Our reference: DOC15/191690-23

RE: Request for Review of Response to Submissions for Moorebank Intermodal Terminal (SSD – 5066)

Attachment A – The EPA's comments regarding review of the Response to Submissions for the proposed Moorebank Intermodal Terminal Facility EIS (SSD – 5066)

**Figure 8.12 Indicative IMT layout associated with the southern rail access option (at end of Phase C) - 2030**

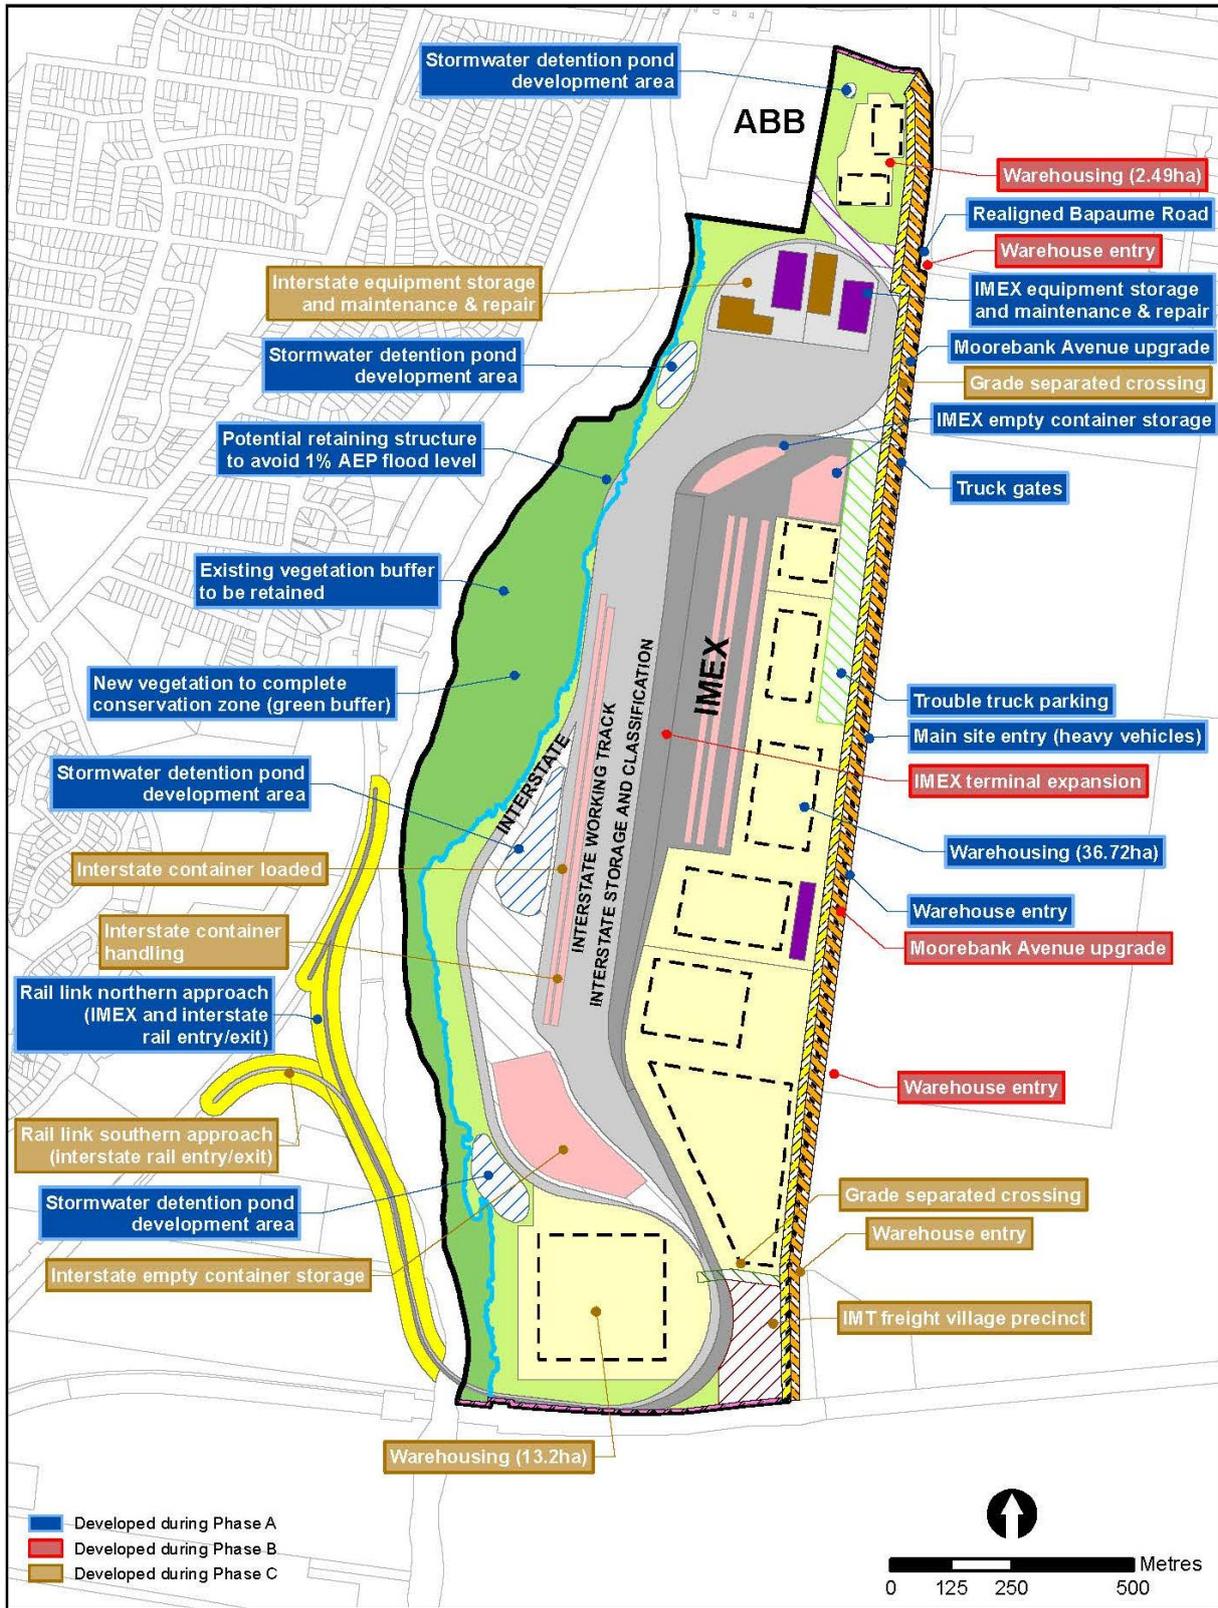
The original project concept for site included 3 options available for the project to connect the rail links to the SSFL. The Southern rail access option has now been selected as the preferred option. The EPA has

concerns with the Southern rail access option, as of the three options originally proposed it will have the most impact on the Glenfield Landfill.

The EPA will not support approval of the southern rail access option until such time as the proponent is able to clearly demonstrate to the EPA that the construction and operation of the rail link will not compromise the effectiveness of the landfill pollution control and monitoring systems (i.e. leachate, landfill gas and surface drainage) at the Glenfield Landfill licensed premises, including future post-closure care measures.

The EPA cannot support any works that have the potential to disturb the landfill cap or barrier system such as excavation or piling because the proponent has not detailed mitigation strategies to deal with leachate and the leachate management and barrier system. The proponent has committed to routine monitoring of leachate and groundwater levels in a Contamination Management Plan to be included in a Construction Environmental Management Plan which were either not presented nor in "preliminary" form at the time of exhibition of the EIS. Further, the EPA is concerned that there is no commitment to monitor leachate and groundwater into the future to determine if the proposal is having an ongoing impact.
